From: Damian Sullivan
Sent: 11 September 2014 11:59
To: Andrew Fuller
Subject: RE: CM/30/14/HH - Poole Place, Climping

From: Estella [REDACTED]
Sent: 10 September 2014 12:37
To: Damian Sullivan
Cc: AFA
Subject: CM/30/14/HH - Poole Place, Climping

We would like to substitute a couple of drawings under the above application reference. Please find attached drawings 102A & 105A

14637/ 105

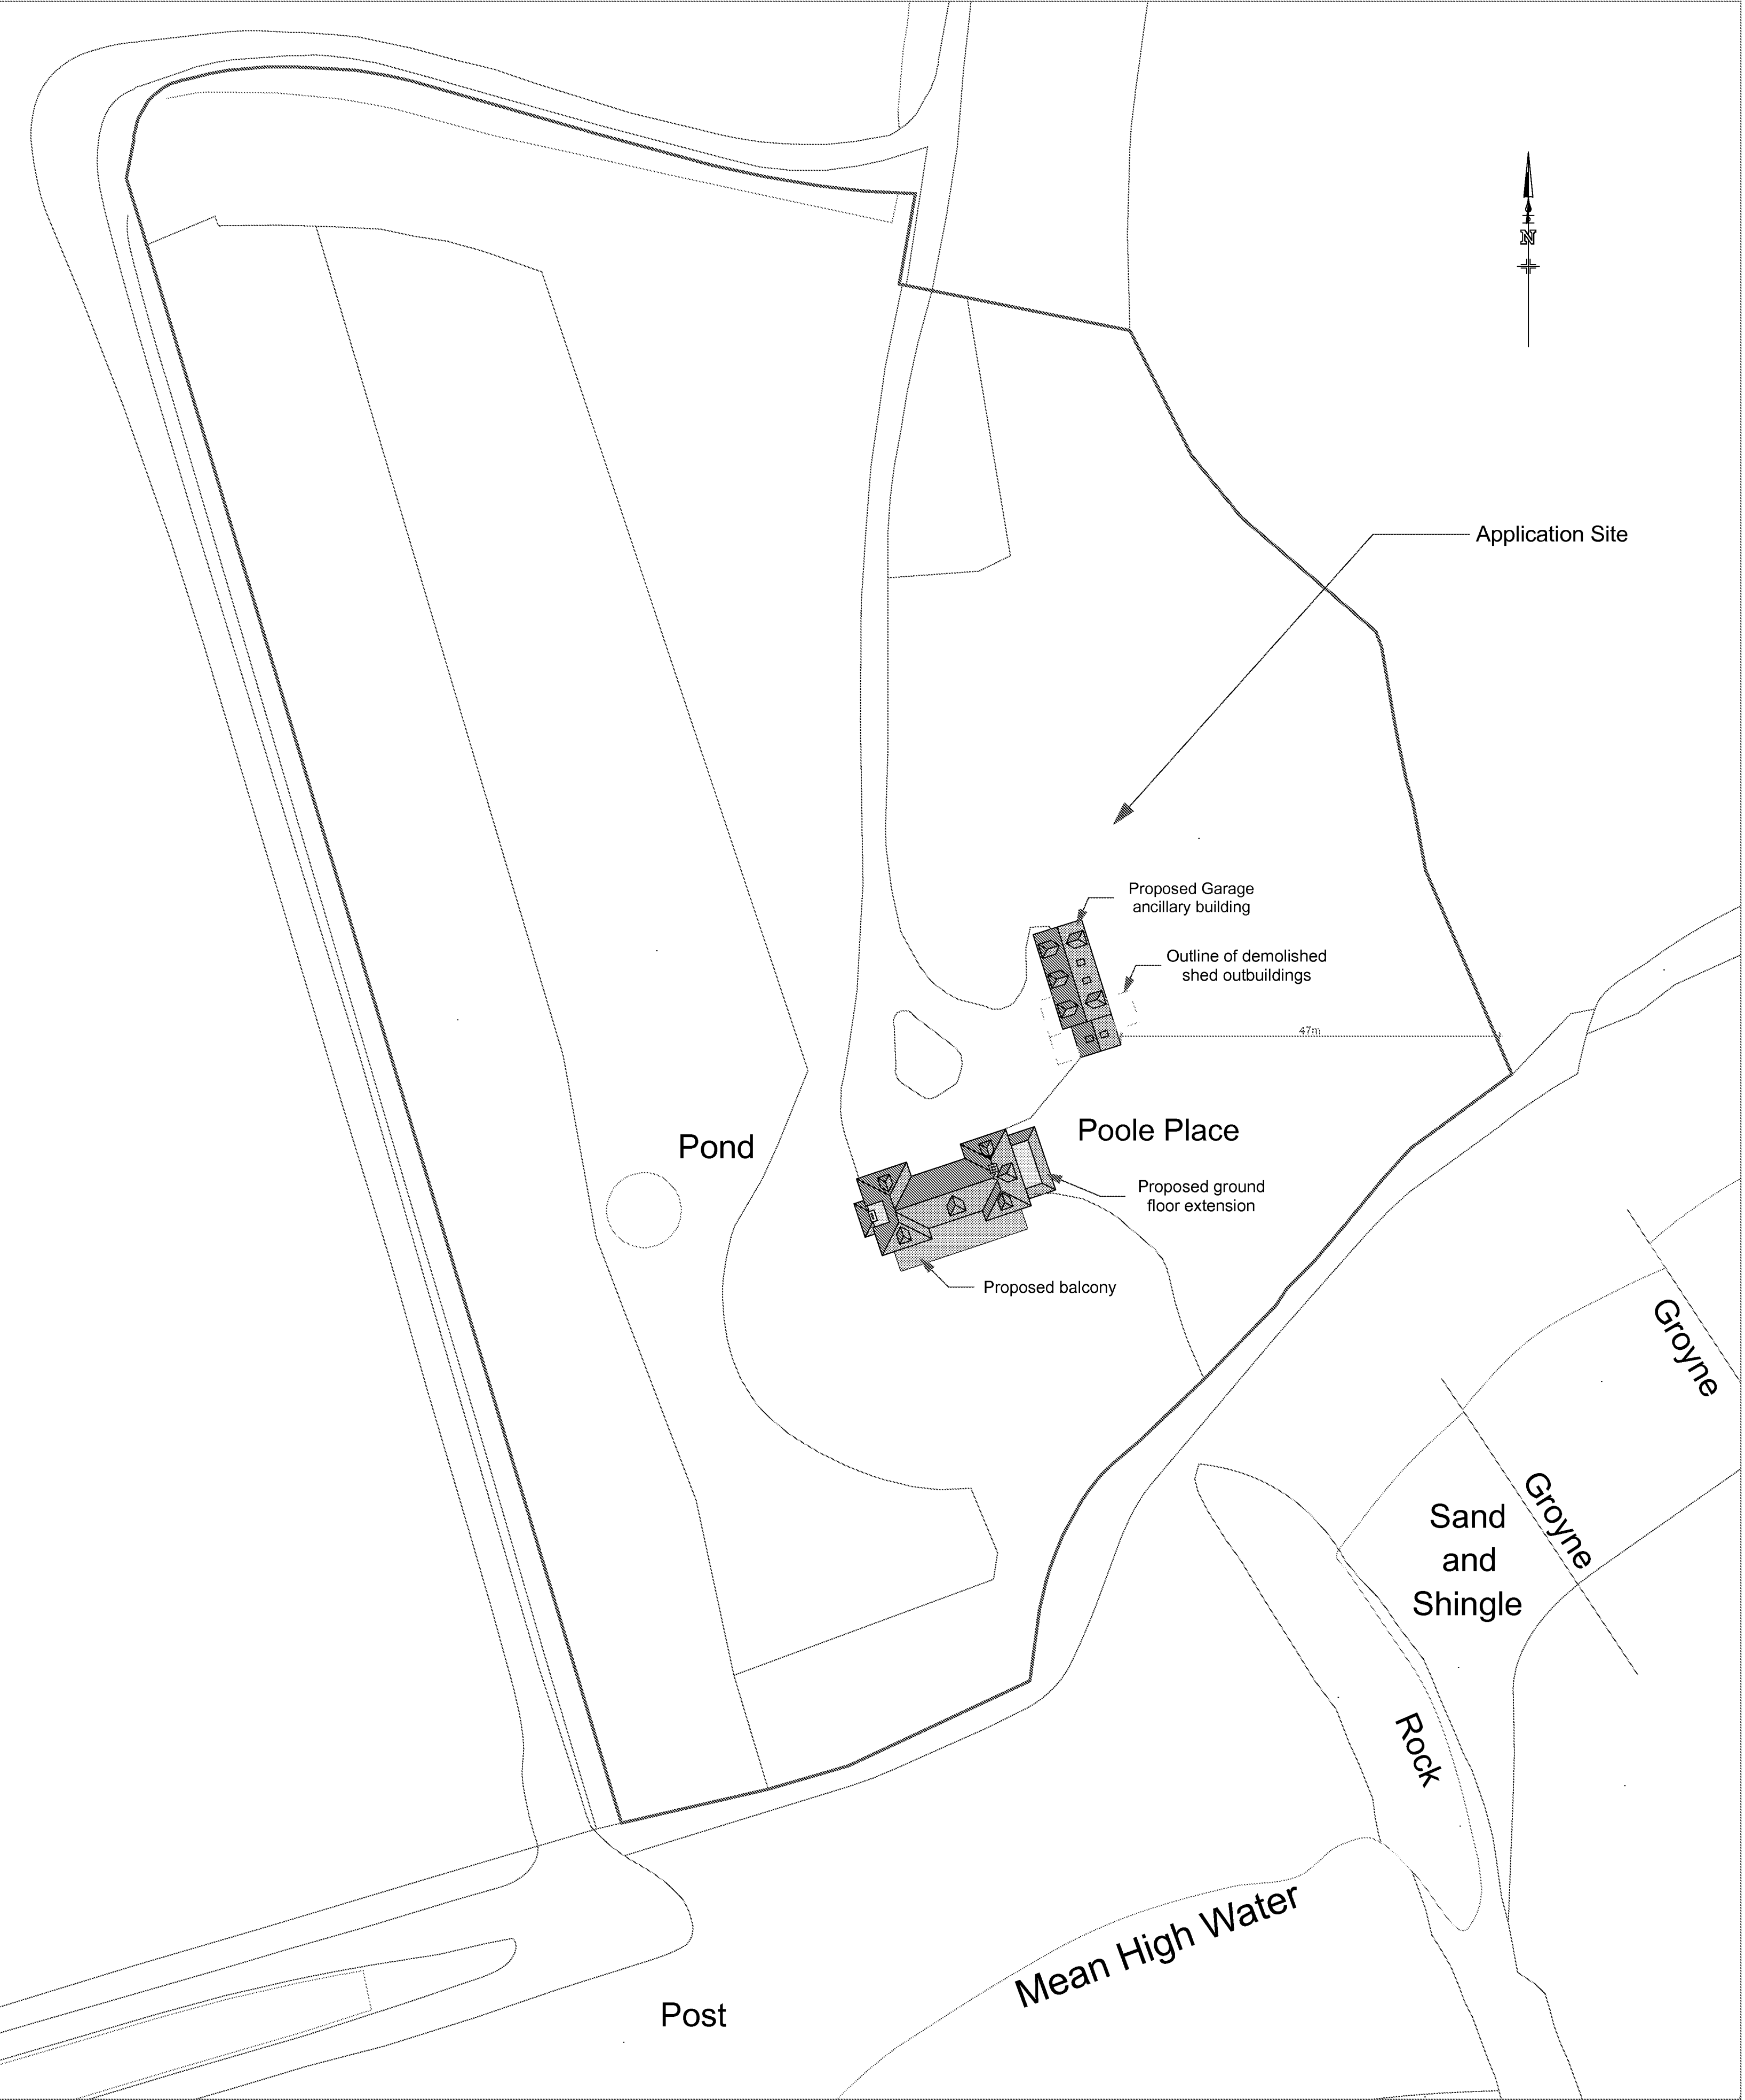
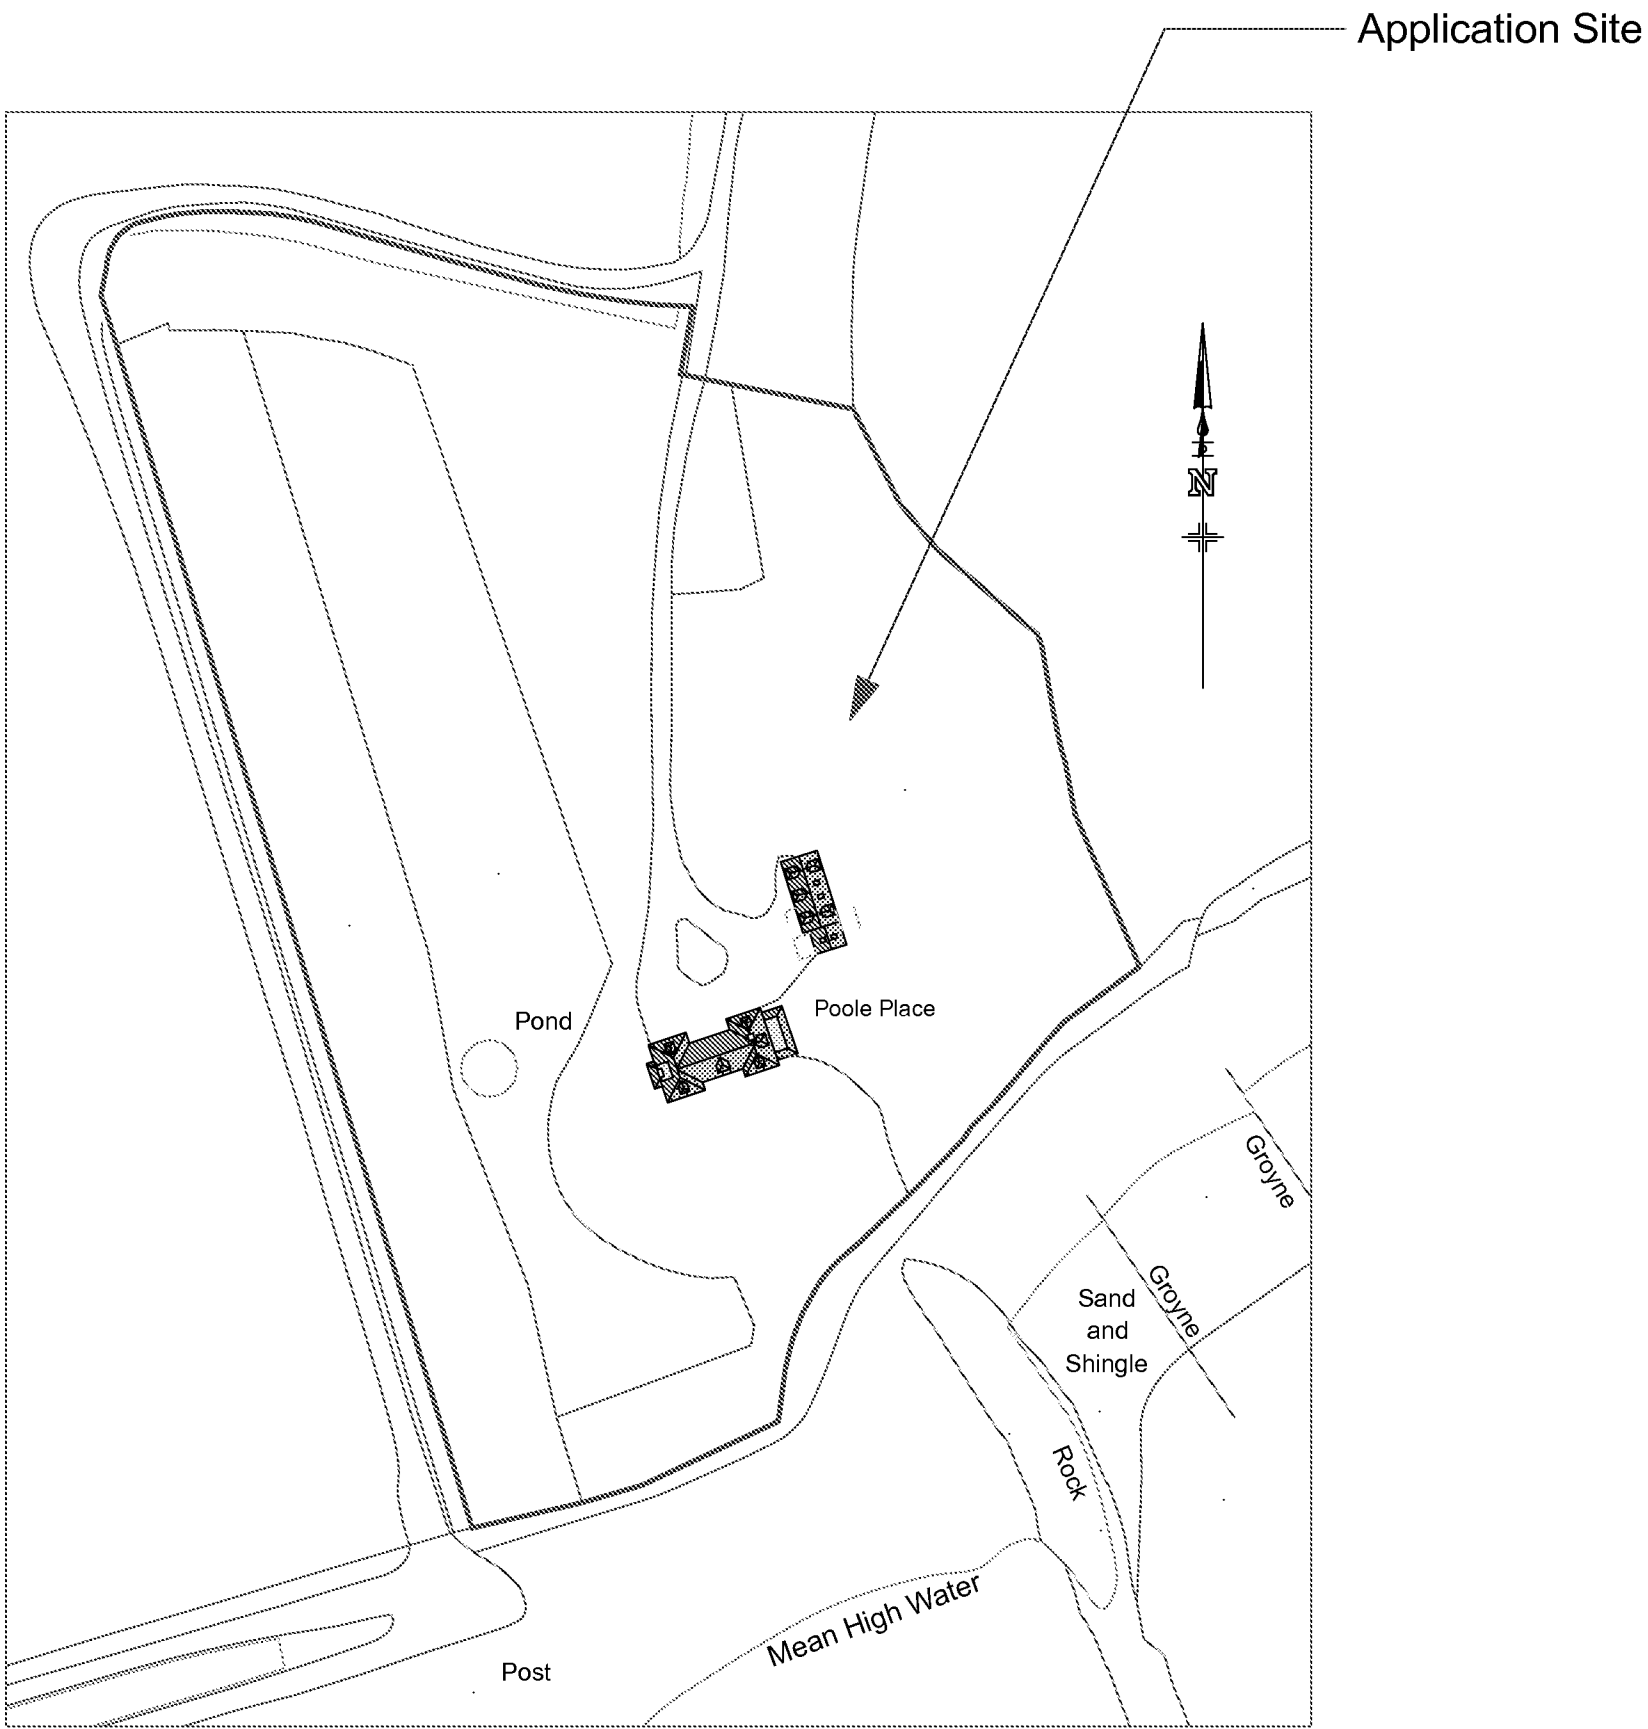
I note your intention to leave the application as it stands. If the swimming pool is shown on the plans, then we are obliged to consider it regardless of whether it needs planning permission. A planning application would not determine it as requiring planning permission as only a Certificate of Lawfulness for Proposed Use (CLP) can do that. I would direct your attention to Class E of the General (Permitted Development) Order 2008 Amendment where in the vast majority of cases, swimming pools are Permitted Development, subject to certain criteria which you can check via <http://www.legislation.gov.uk/uksi/2008/2362/made>

Please could you advise if the swimming pool needs to be considered? It is simply included in the updated Site Plans. Would a plant/pool building need PP? I think it would normally be within PD?

Unfortunately due to the changes being made especially the swimming pool, although even the dormers on the east elevation, mean that these cannot be accepted as substitute drawings as they will require re-advertising. You are of course welcome to withdraw the application and start again with a resubmission at this point.
